Our Reference: SYD19/01350/12  
Departments Reference: SSD-10448

**RESPONSE TO SUBMISSIONS - ASPECTS INDUSTRIAL ESTATE – LOTS 54-58, DP259135 - MAMRE ROAD - KEMPS CREEK**

Reference is made to the Department's referral dated 9 March 2021 with regard to the abovementioned State Significant Development Application (SSDA), which was referred to Transport for NSW (TfNSW) Services for comments.

Status	FOR APPROVAL	A1
NOT TO BE USED FOR CONSTRUCTION		
Project - Drawing No.	18-596-C0040	Issue
		B

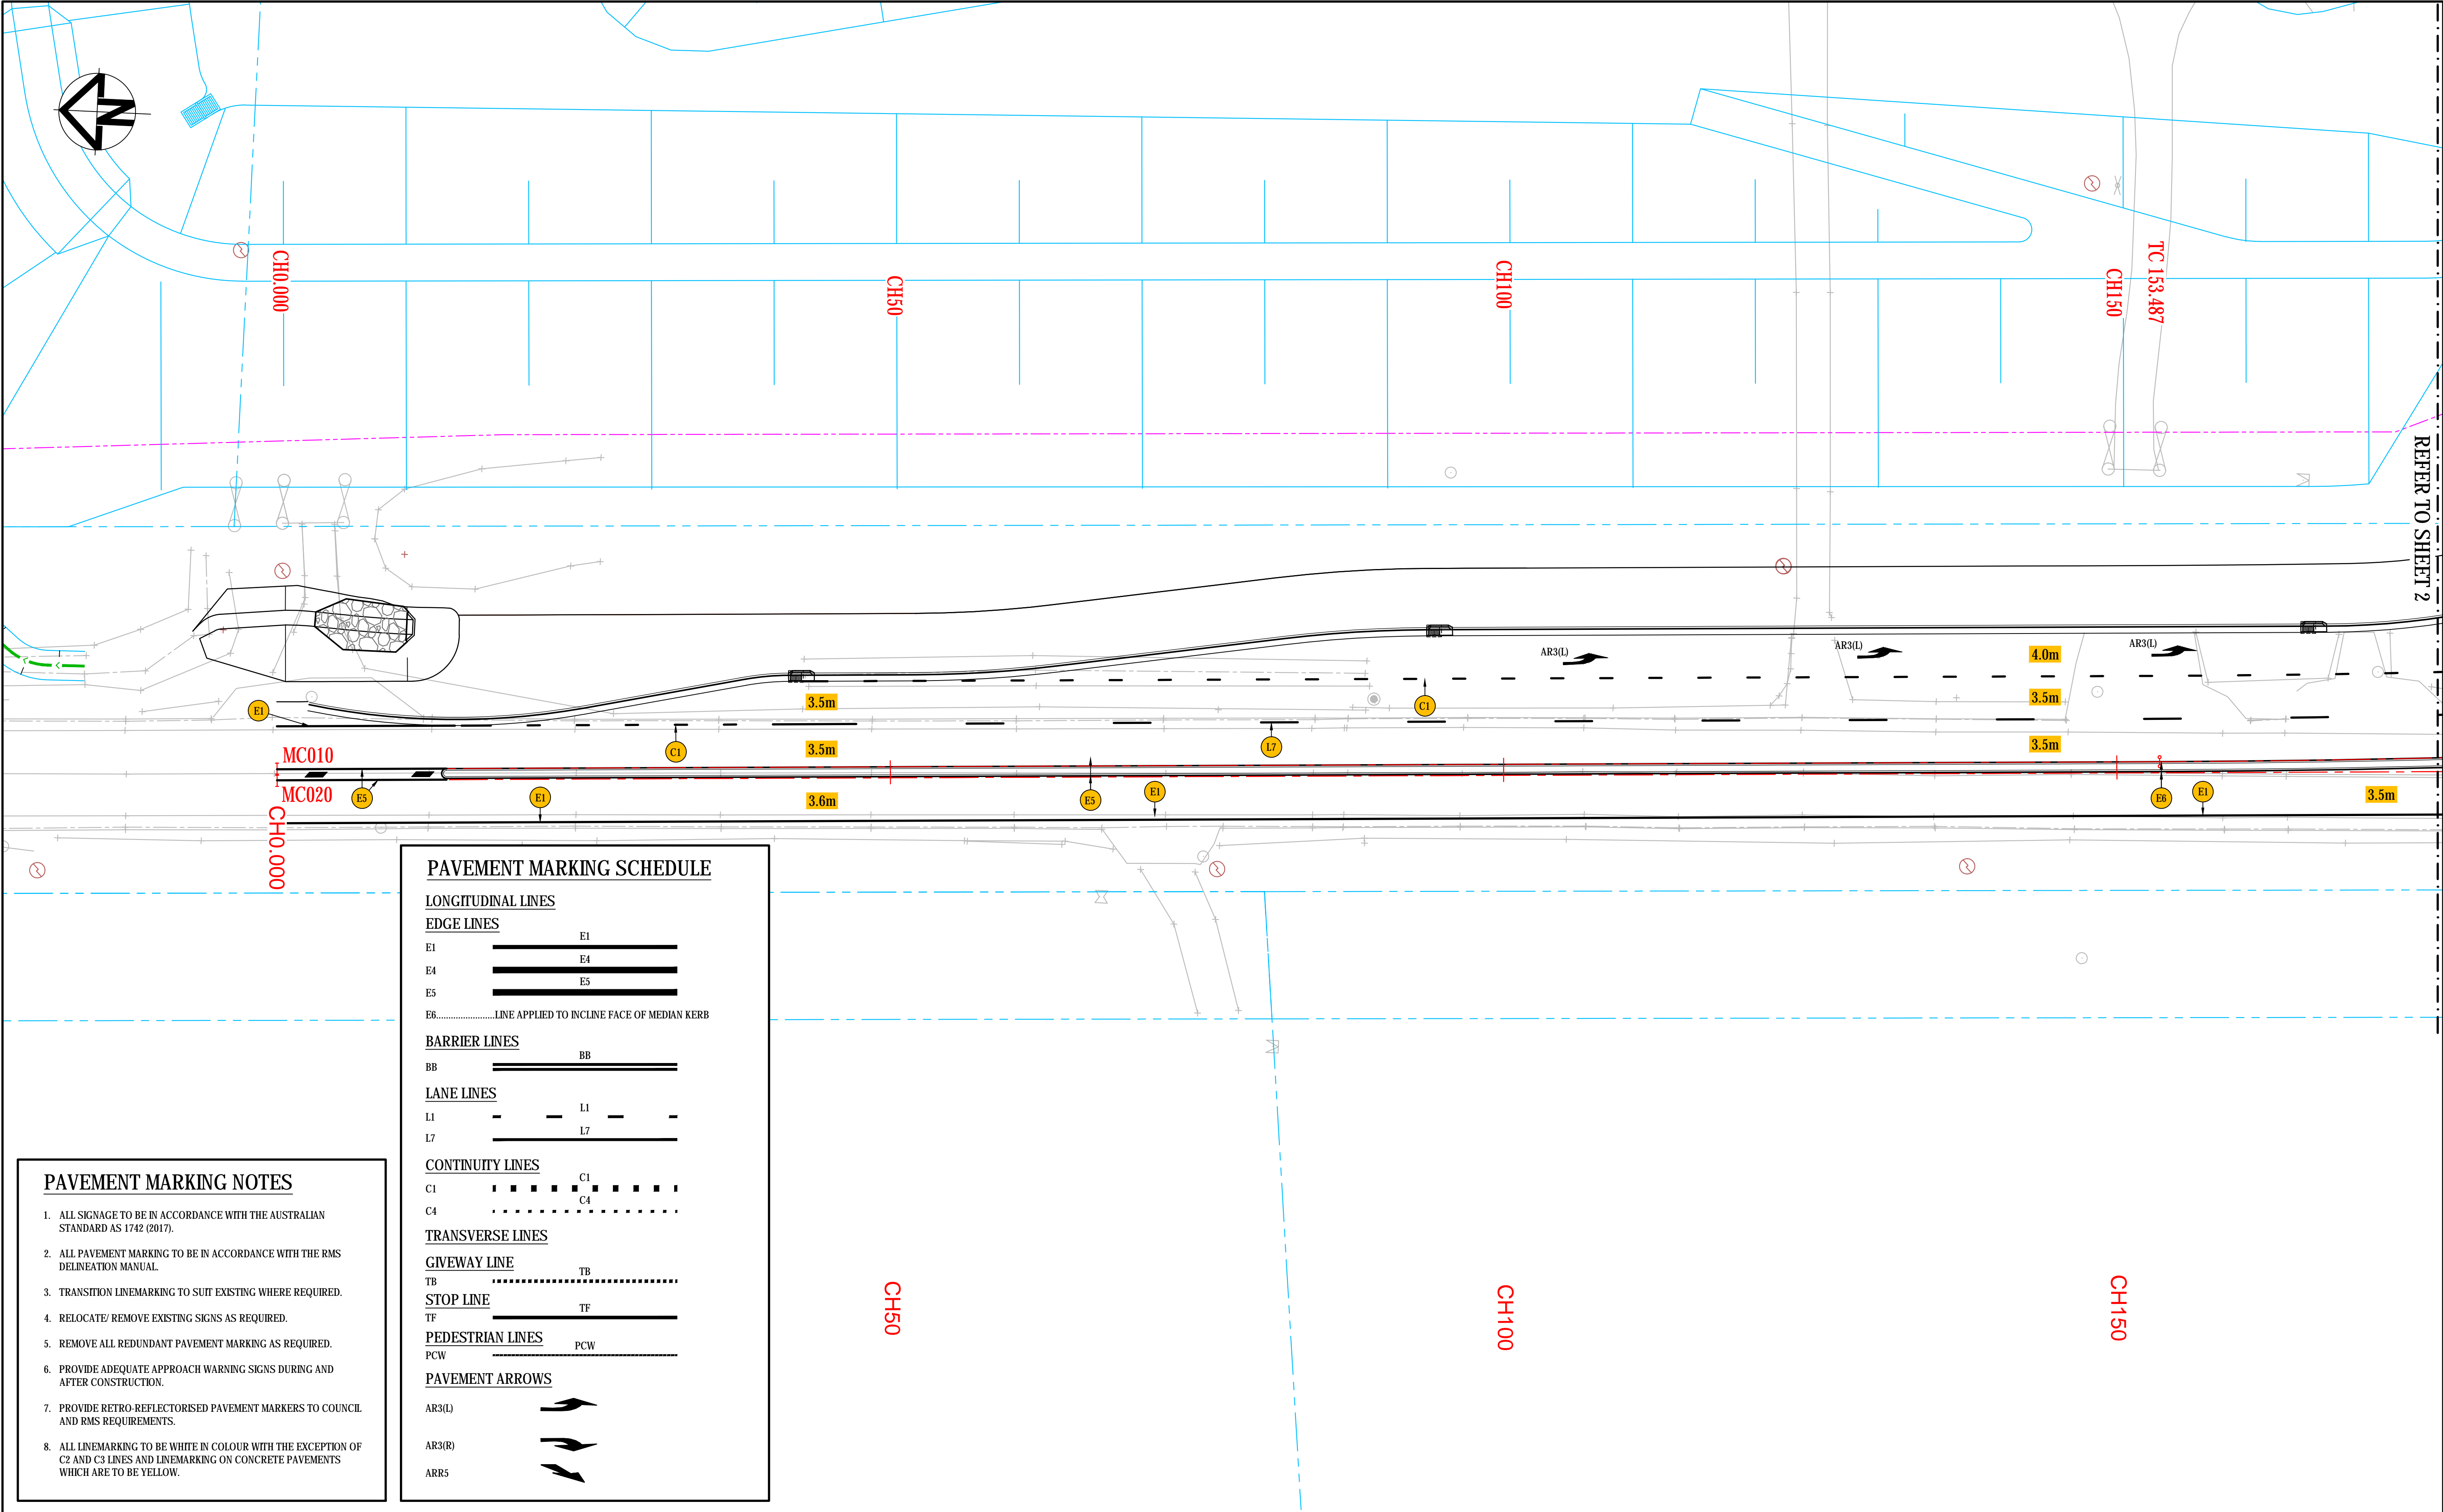
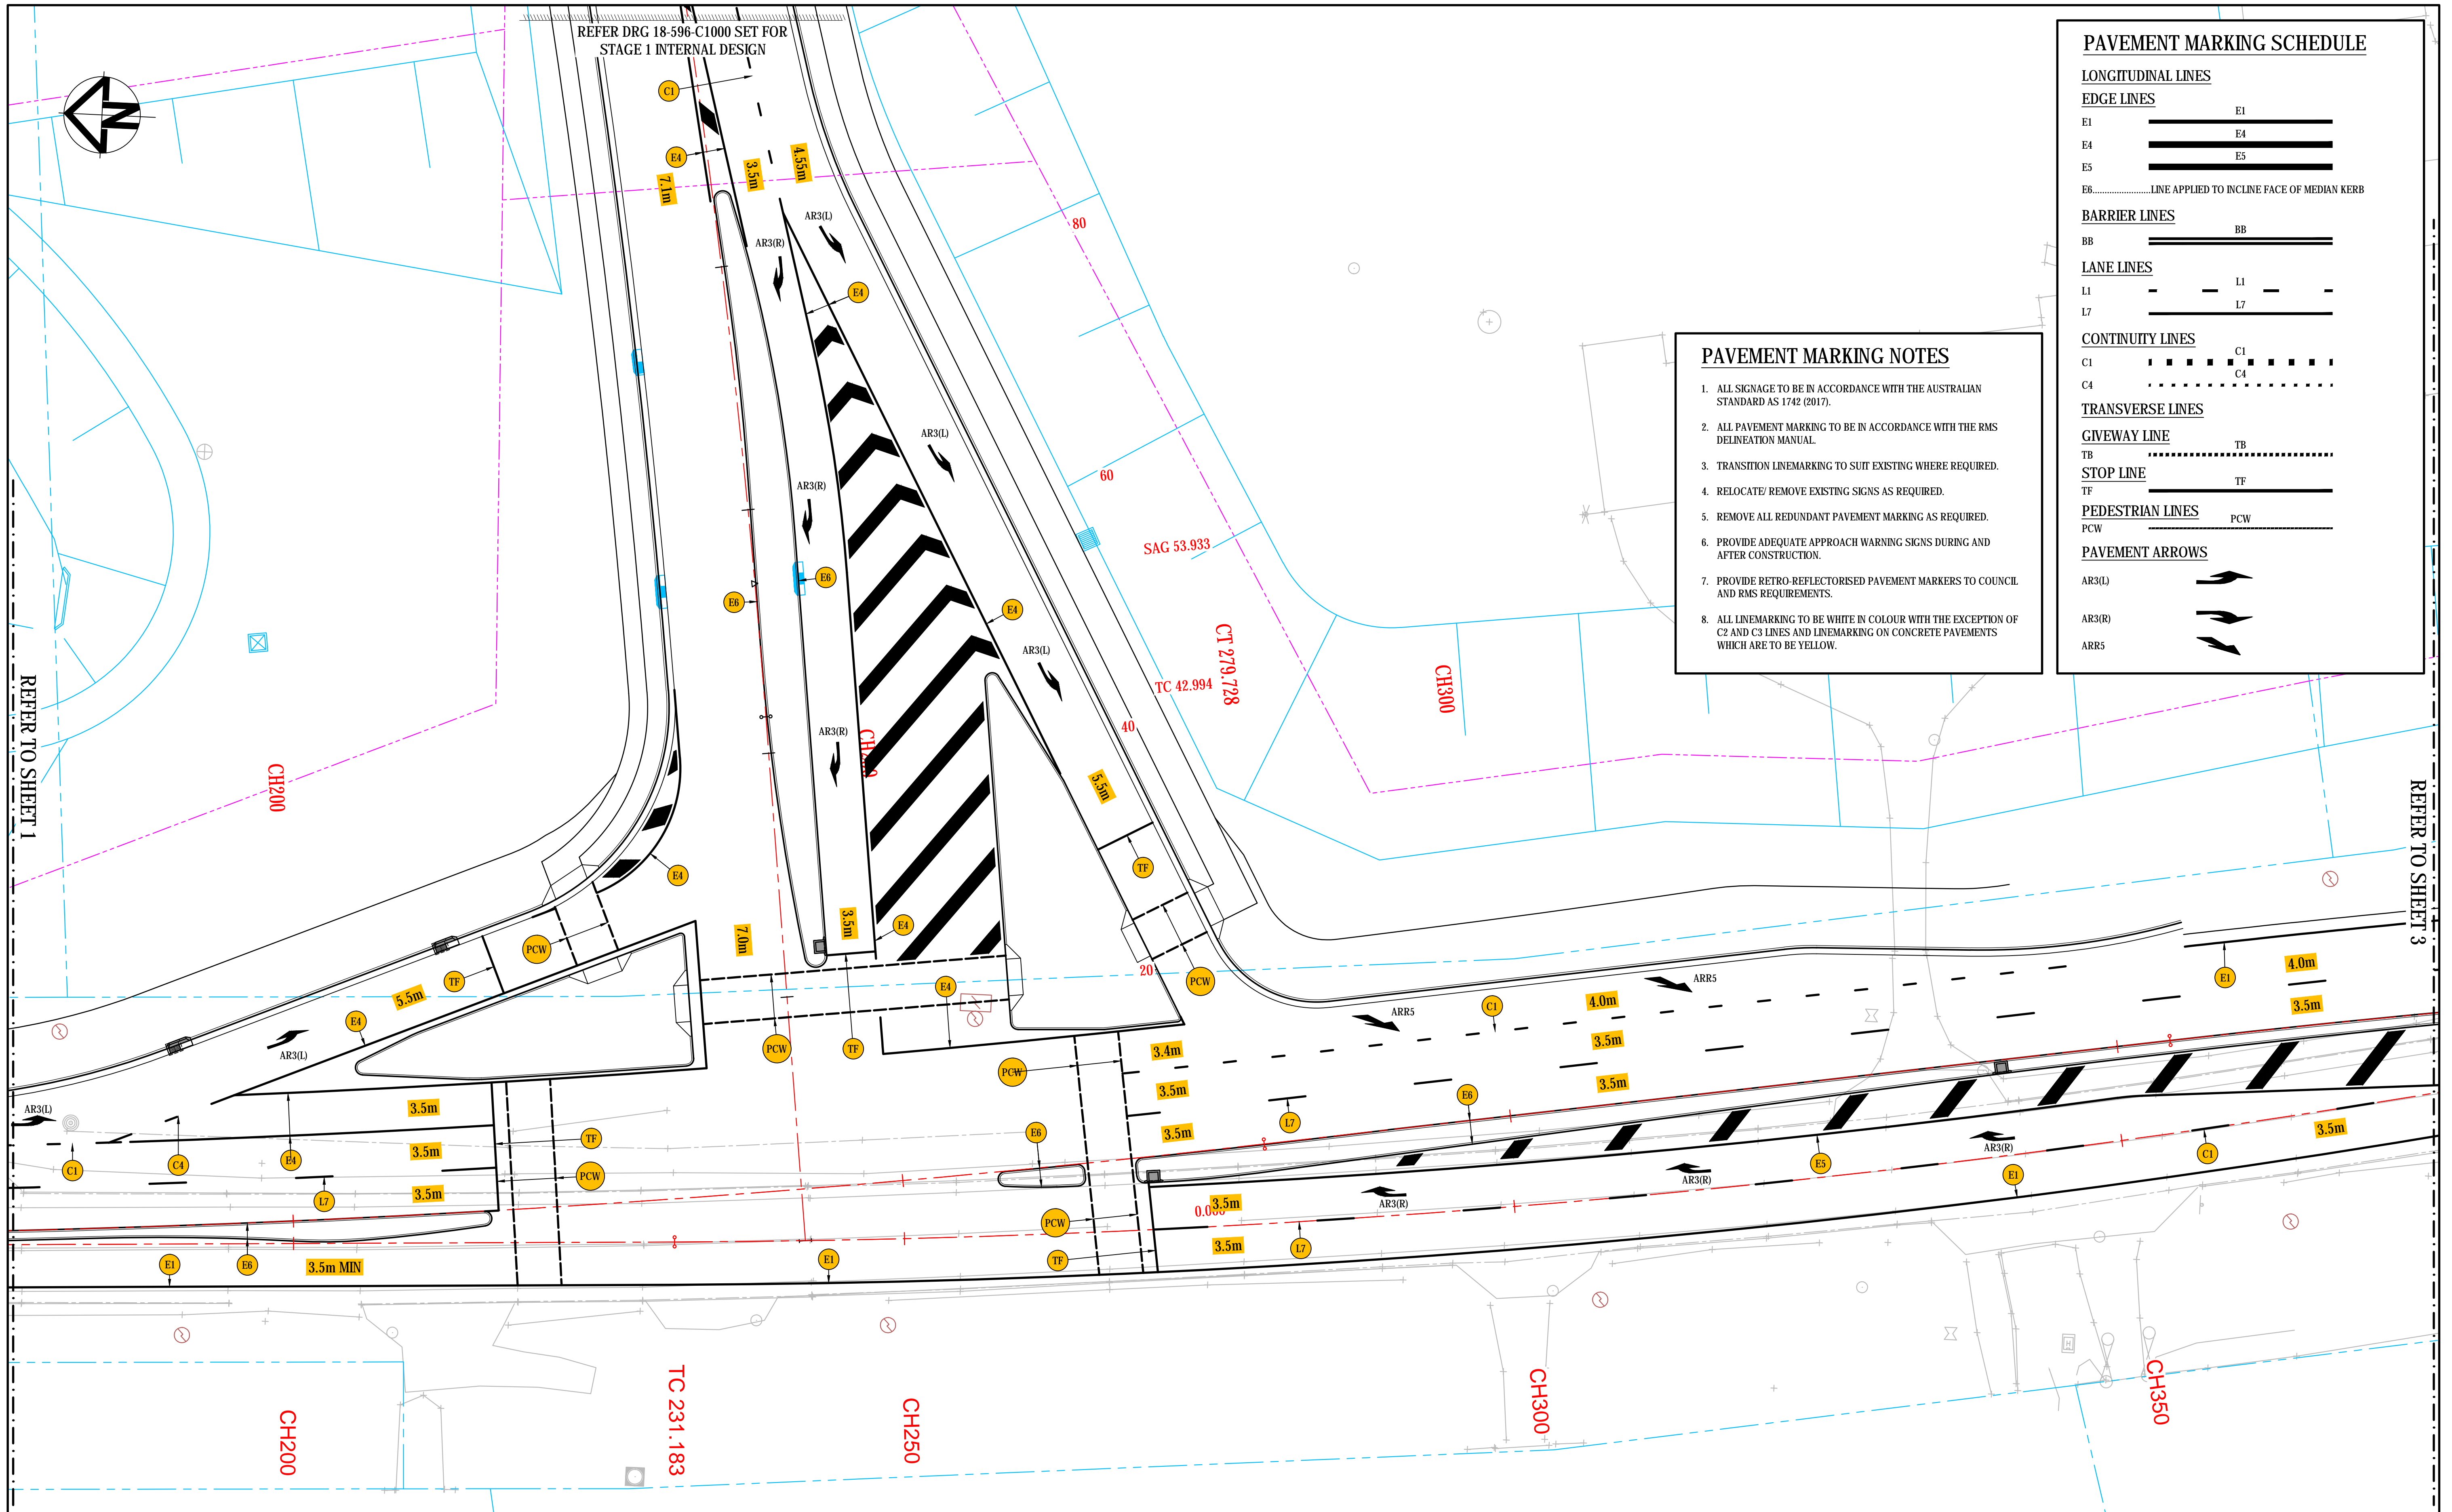
*TfNSW Item 3g* – Further to TfNSW comments provided in the previous submission, when there is no pedestrian activity, an exemption can be requested, so that no installation of lanterns and line marking is required. However it should be noted that the hard infrastructure is still required to be constructed and the geometry is still required for the lanterns and line marking to be included at a later date (if necessary).
